Submission No.			283	
Organisation Name or Name of Submitter			Smyths Toys Superstores (represented by RW Nowlan & Associates)	
Item No.	Section Ref.	Page No.	Observation Statement	TII Response
Submission on Proposed Railway (Metrolink - Estuary to Charlemont Via Dublin Airport) Order (2022)				
1	Executive summary	1	Under the proposed Railway Order the existing store would need to be demolished. The implications of the loss of this store to the area would be significant given the expected population growth in the area.	Where Smyths Toys Superstores occupational interest at Airside Retail Park is to be acquired by the use of compulsory purchase powers then they would be entitled make a claim for compensation in accordance with the compensation code. The Code provides that qualifying occupiers can recover the reasonable costs of relocation which have been properly and necessarily incurred as a direct consequence of the acquisition.

Drawing Title	METROLINK - STRUCTURES FOSTERSTOWN STATION PROPOSED STREET LEVEL DESIGN		Drawing Status	S0
Drawing N°	ML1-JAI-SRD-ROUT_XX-DR-Y-02016	Plan Drawing N°	ML-ST 301 T-U1	
Scales Original Size A1	1:250	Sheet	1 of 6

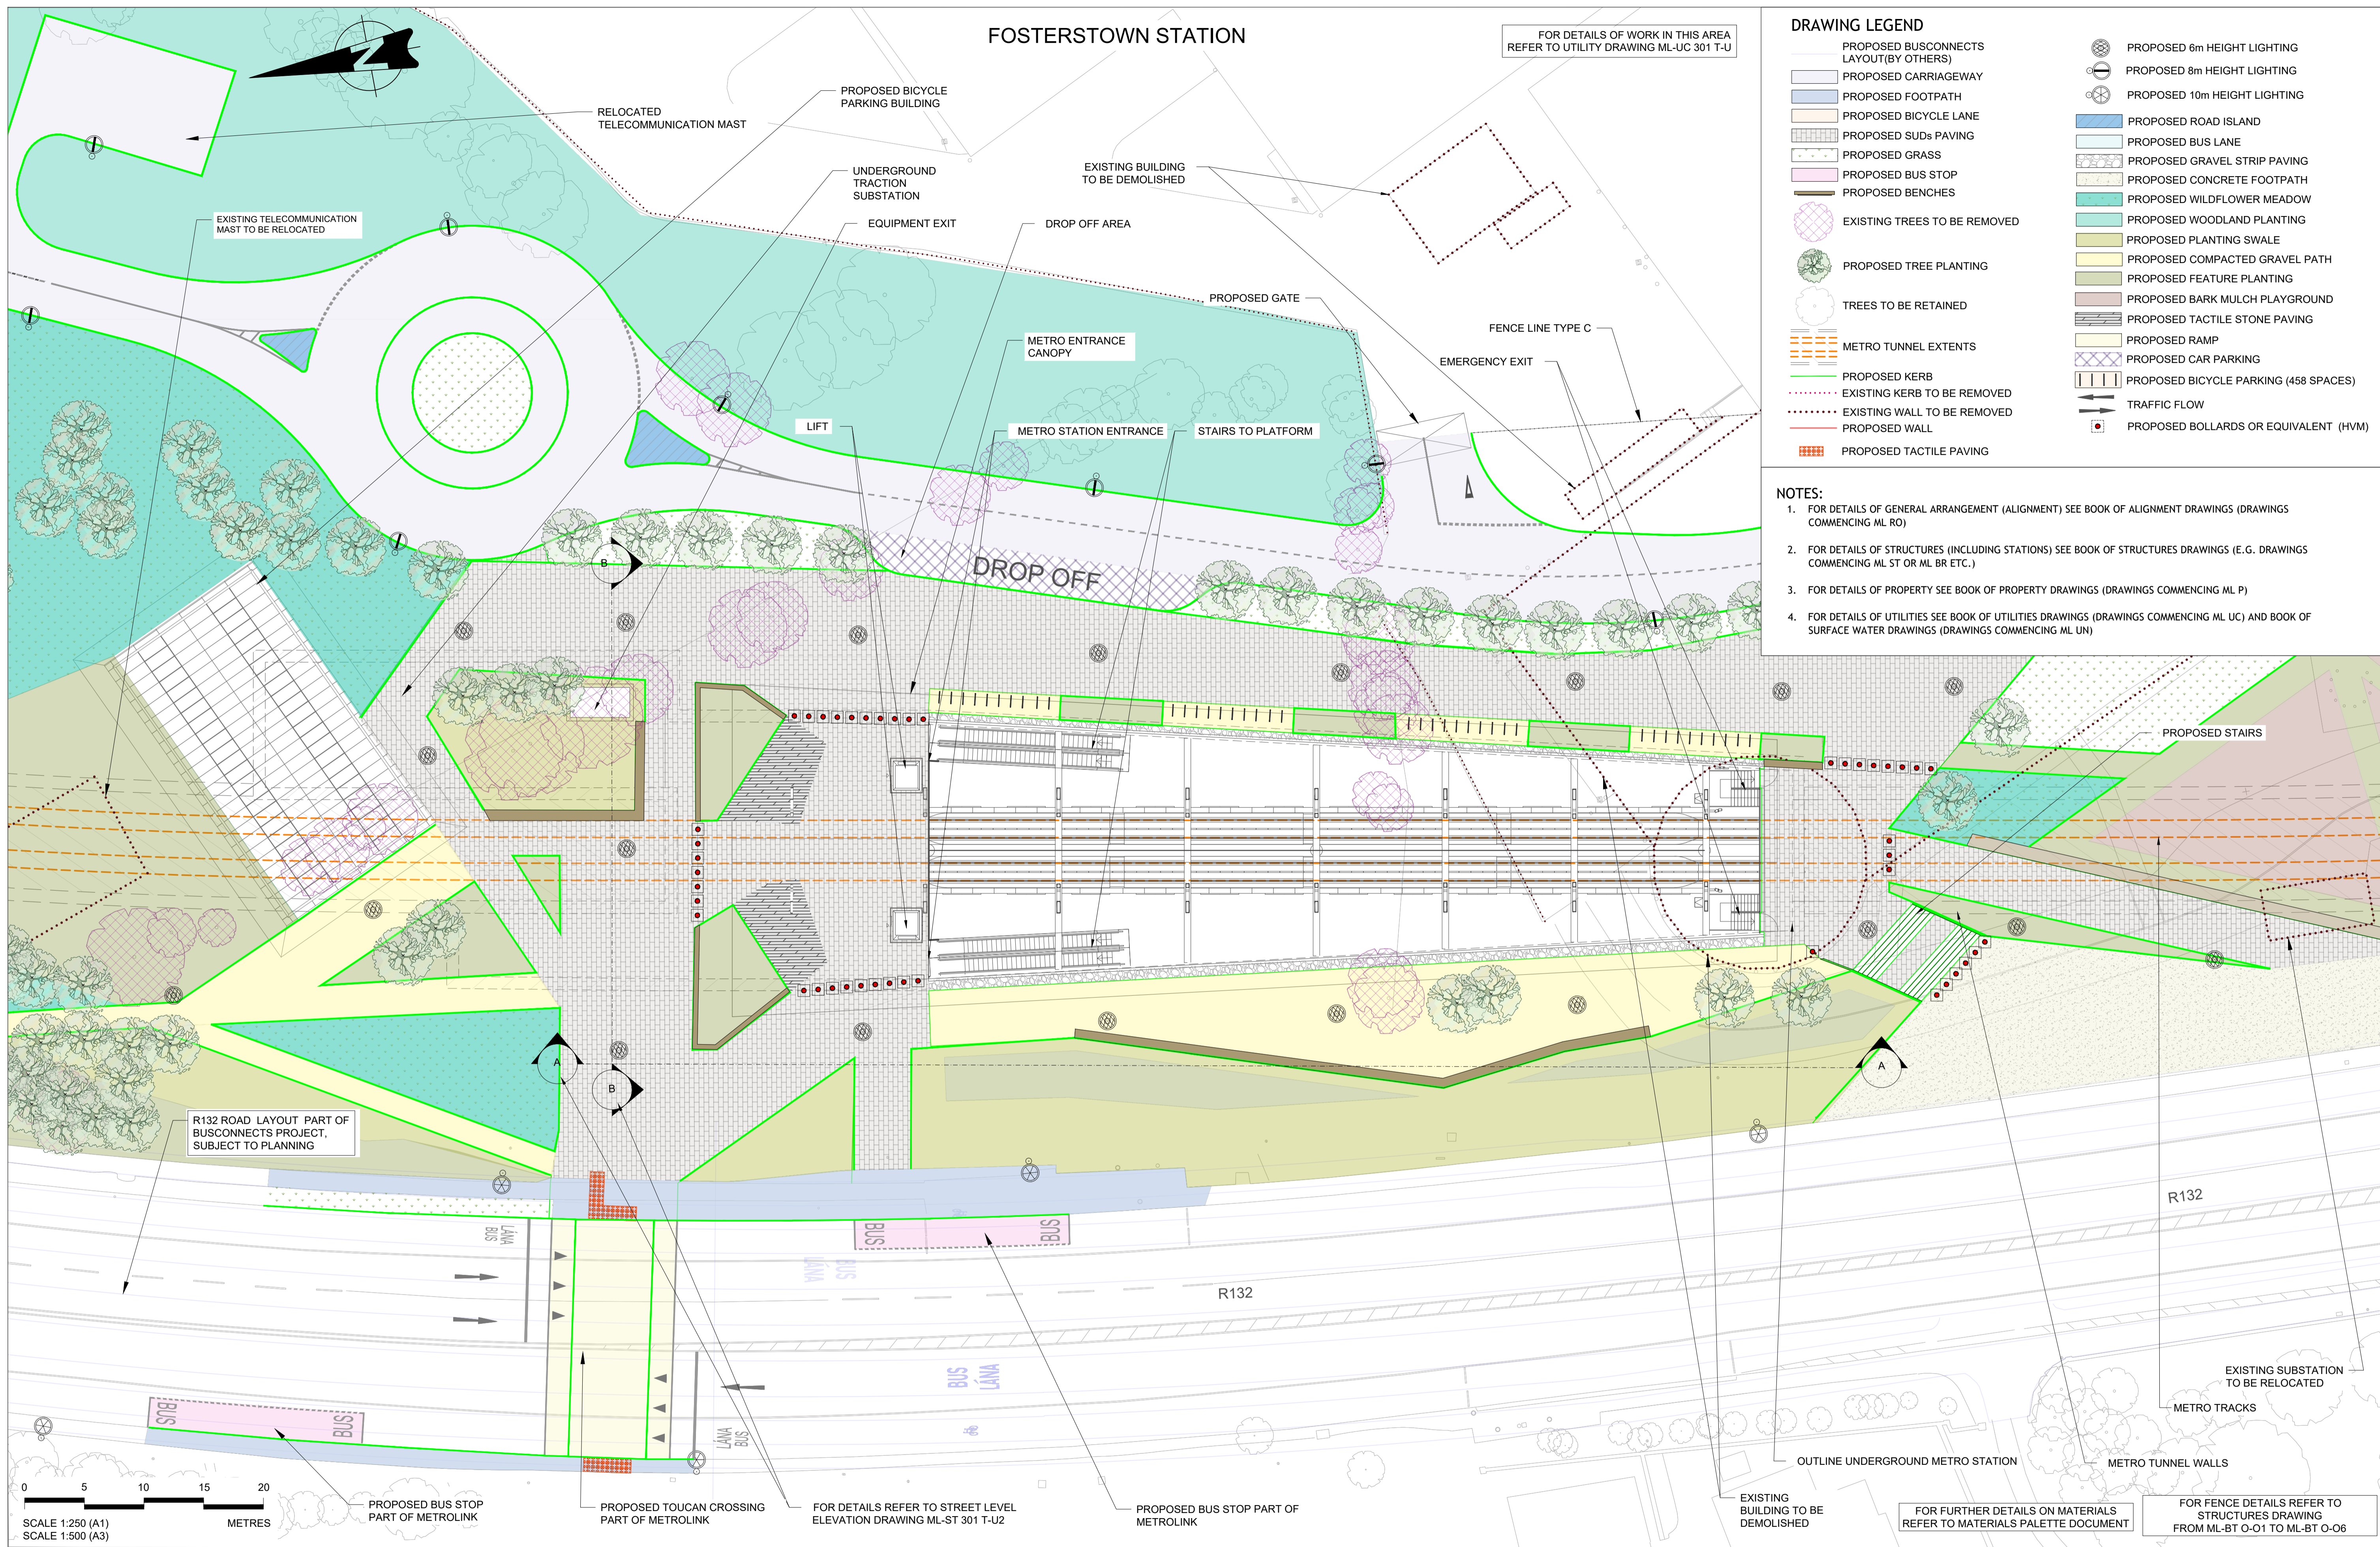
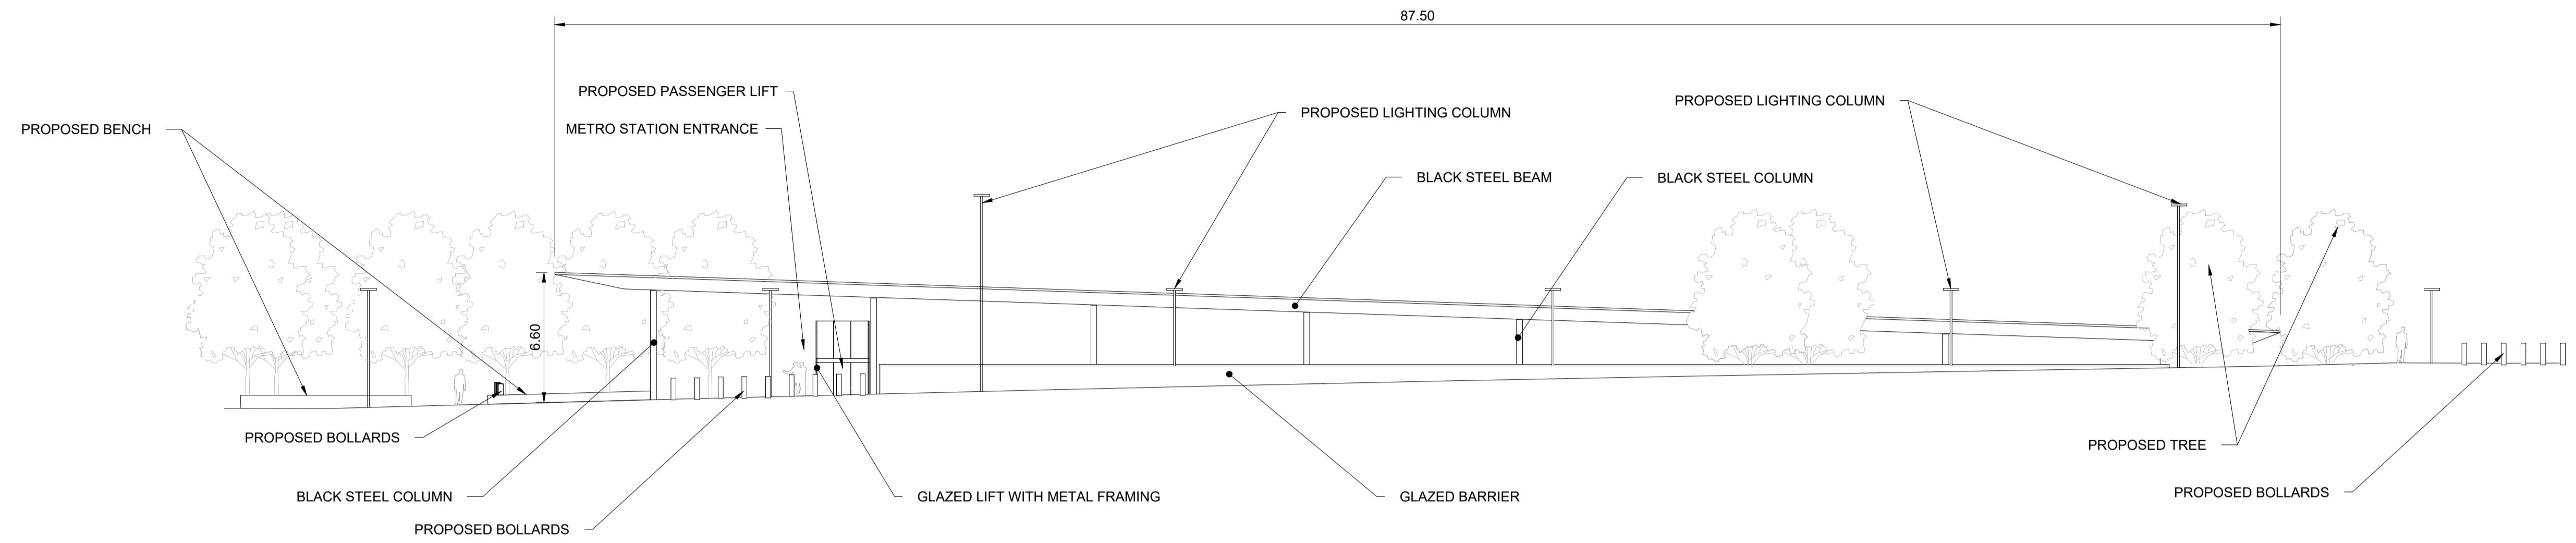
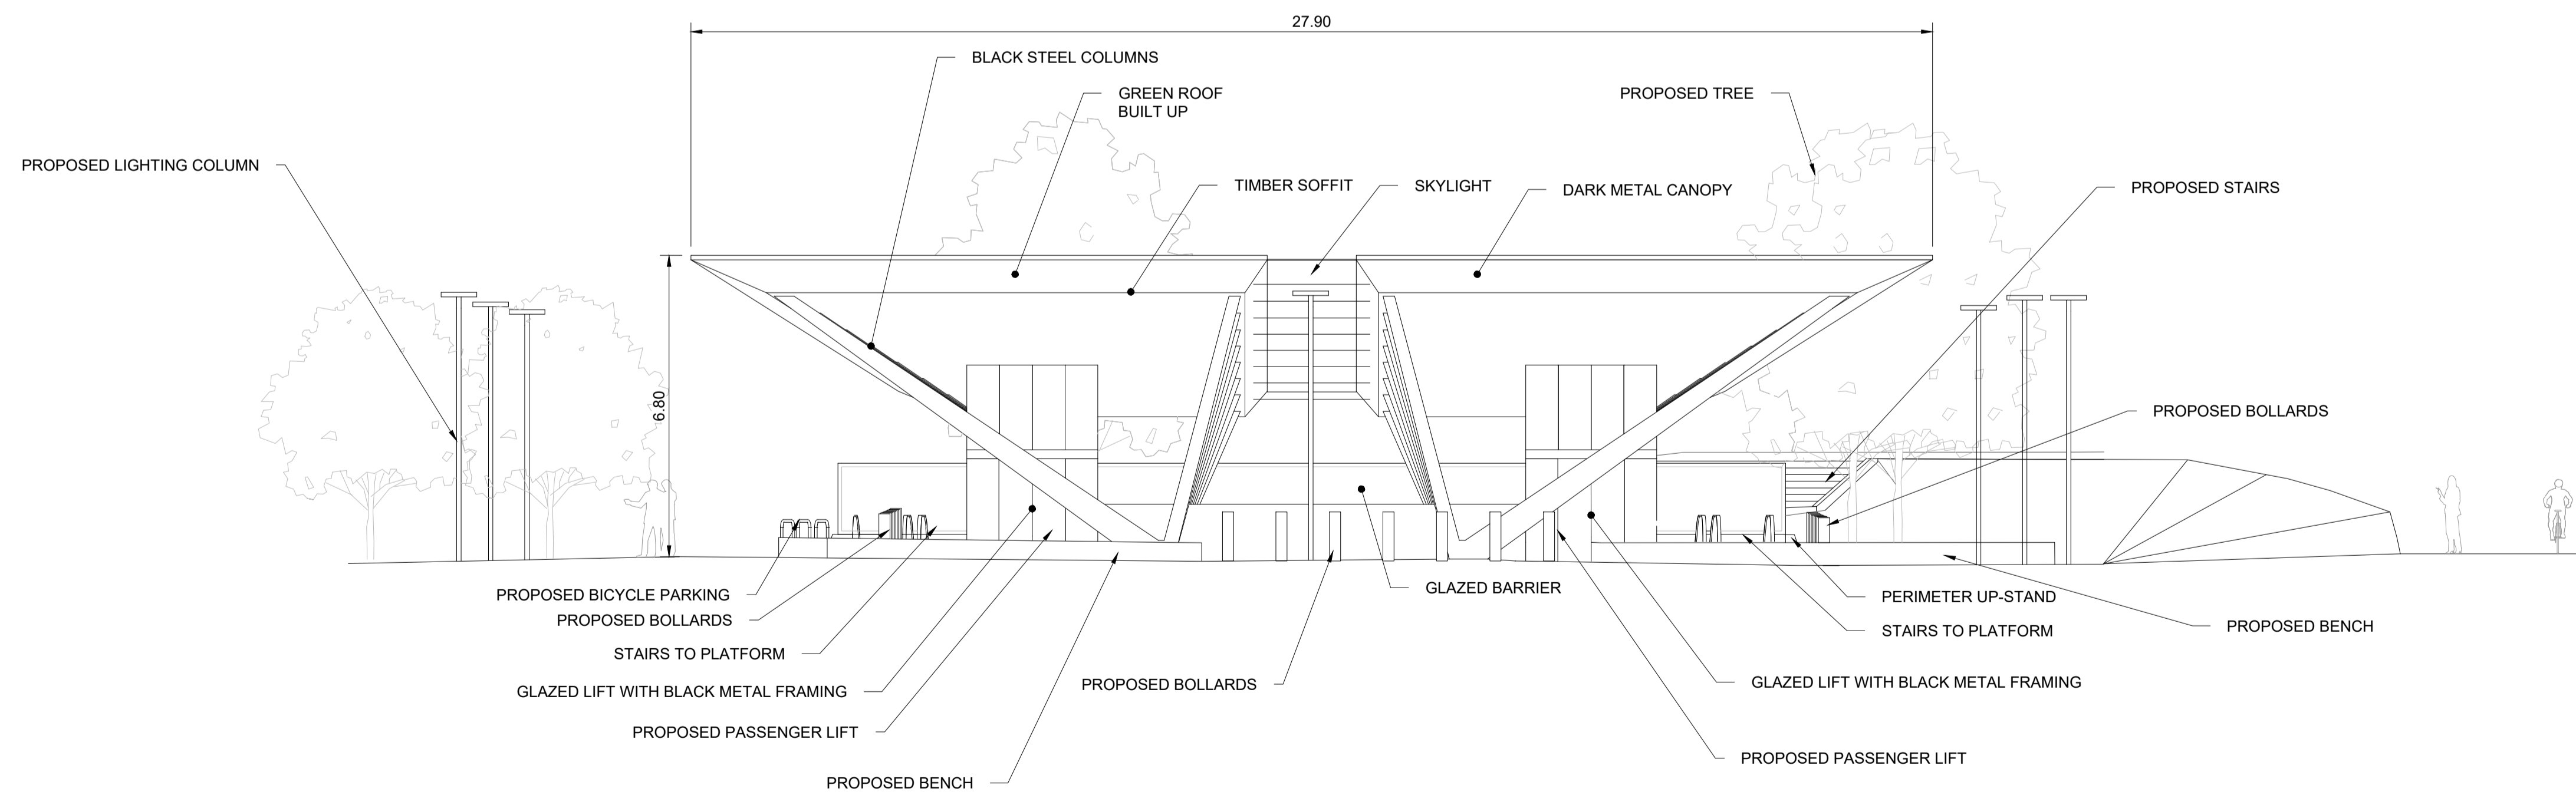
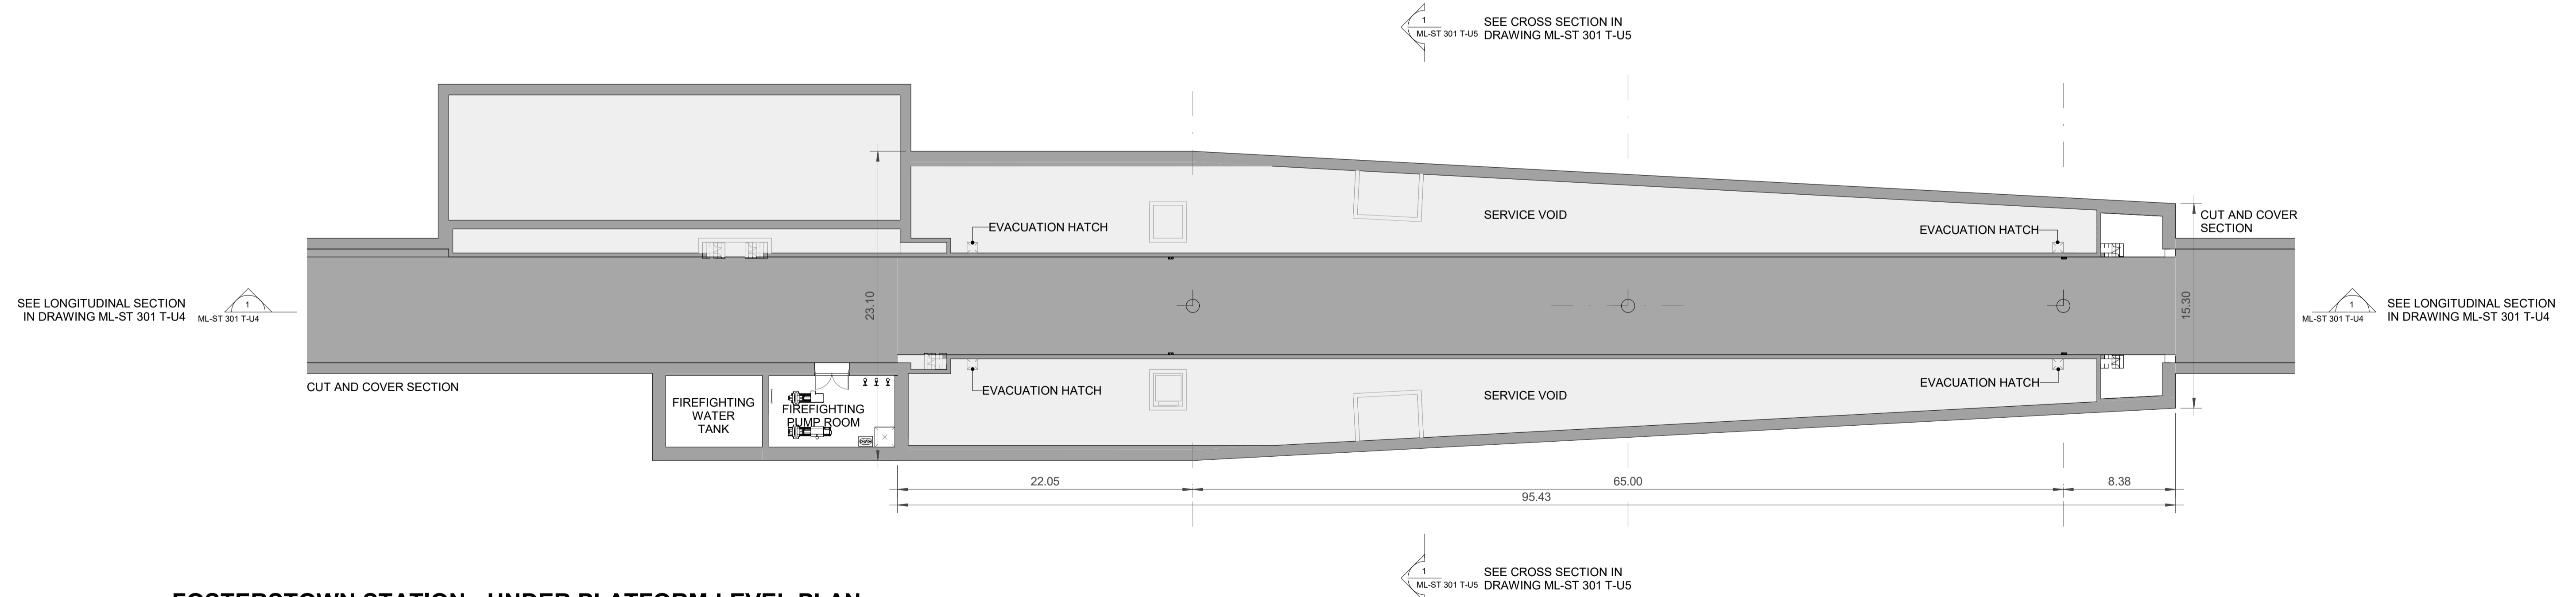
6	6.0 Fosterstown Station Materially Contravenes the Development Plan	5	6.2 The zoning objective in the draft development plan (which will soon become the operative plan) is Retail Warehousing and the objective is: ... <i>"To Provide for Retail Warehousing."</i> The zoning objective for Retail Warehousing does not facilitate the proposed use of a metro railway station. The planning report states the following in this regard: ... <i>"Fosterstown Station lies within lands zoned as HT and RW in the Fingal FDP. Under these zoning objectives, 'public transport station' does not come within either 'Permitted in Principle' or 'Not Permitted' uses. The FDP notes that 'Uses which are neither 'Permitted in Principle' nor 'Not Permitted' will be assessed in terms of their contribution towards the achievement of the Zoning Objective and Vision and their compliance and consistency with the policies and objectives of the Development Plan."</i>  6.3 It is difficult to see how the proposed metro station would contribute towards the objective to provide for retail warehousing. In fact, it does exactly the opposite: it would remove a large retail warehouse building from the retail warehouse park without suggesting an alternative location for this building.  6.4 The proposed development therefore materially contravenes the development plan zoning objective.	As per the Planning Report, Fosterstown Station lies within lands zoned as HT and RW in the Fingal FCDP. Under these zoning objectives, 'public transport station' does not come within either 'Permitted in Principle' or 'Not Permitted' uses. However, the FDP notes that 'Uses which are neither 'Permitted in Principle' nor 'Not Permitted' will be assessed in terms of their contribution towards the achievement of the Zoning Objective and Vision and their compliance and consistency with the policies and objectives of the Development Plan.  Therefore, in consideration of the fact that the proposed project is of strategic importance to the long-term development of the Dublin region for land-use and transport and has been specifically identified as being of national importance in the National Planning Framework, National Development Plan, Fingal Development Plan and other key statutory documents, it is considered that the proposed station is consistent with the strategic policies and objectives of the development plan, and therefore TII do not agree with the observation statement that "The proposed development therefore materially contravenes the development plan zoning objective".

10	9.0 Conclusions bullet 1	8	The proposed demolition of the existing retail store to facilitate the development of a railway station would materially contravene a zoning objective in the current and draft county development plans.	Please refer to response (3) above.
11	9.0 Conclusions bullet 2	9	The proposed railway station is in a different location to that shown in the development plan for the area. The justification for this change in location is not provided in the application for the Railway Order.	Please refer to response (7) above.
12	9.0 Conclusions bullet 3	9	No provision is made in the proposed Railway Order for a replacement or relocation of the existing retail store even though the demolition of the existing store is stated to be necessary	Please refer to response (8) above.
13	9.0 Conclusions bullet 4	9	While the planning report refers to 'capacity" to construct a new unit to replace the demolished unit nothing has been proposed and it is unclear where the capacity exists.	Please refer to response (8) above.
